Recommendation Report for Planning Permission for Works or Extension to a Dwelling

REF NO: A/164/18/HH

LOCATION: 4 Heathfield Avenue
Angmering
BN16 1AL

PROPOSAL: Ramp to front, associated door widening & associated hardstanding.

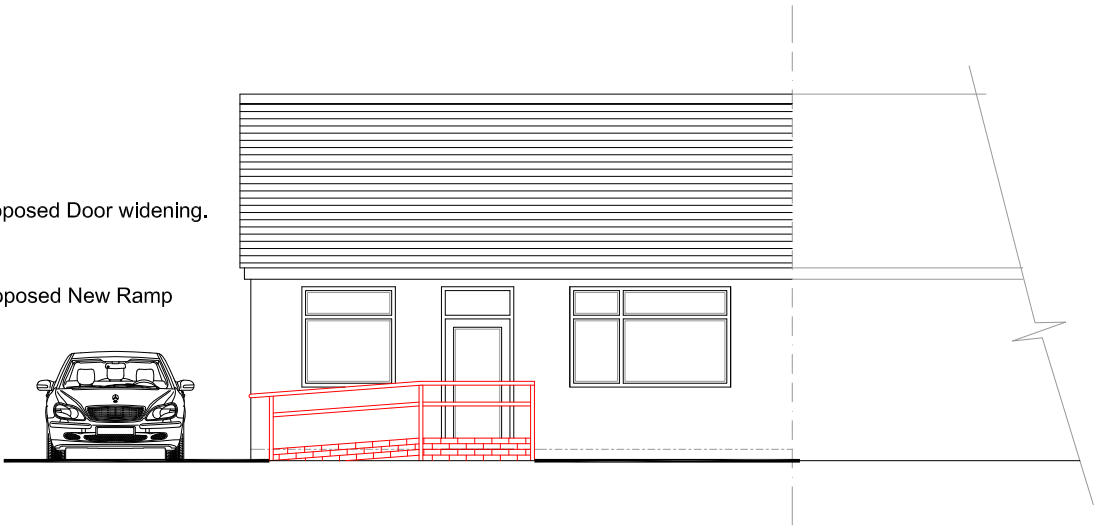
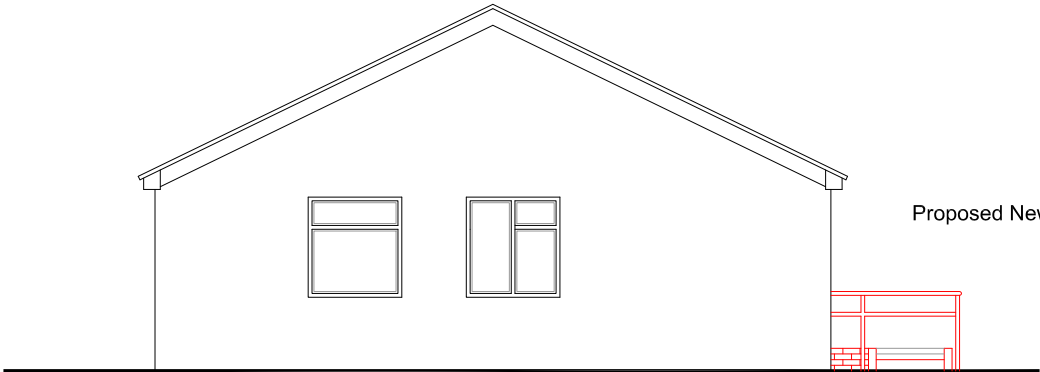
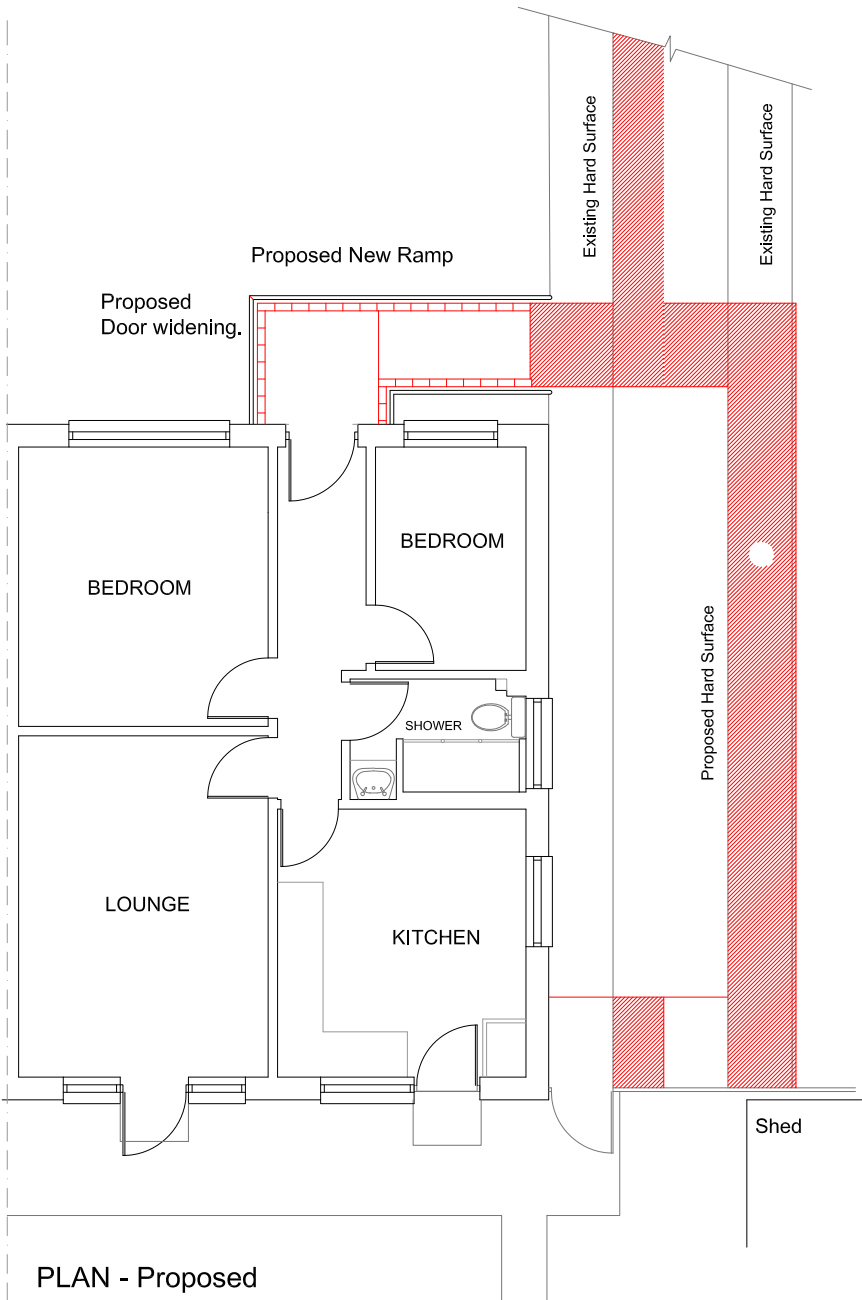
As a result of its siting, the proposed access ramp is visible within the street scene, however, due to its modest scale and design, it is not considered to have a significantly detrimental impact on the character of the host dwelling and the surrounding area. The maximum height of the ramp is low, and as such, the proposal is considered to appear sympathetic and subservient to the host dwelling.

The proposed access ramp is not considered to be overbearing as a result of its modest scale and light

construction. Therefore, it is not considered that the proposal will give rise to any unacceptable adverse overbearing, overshadowing or overlooking impacts upon the neighbouring residential amenity
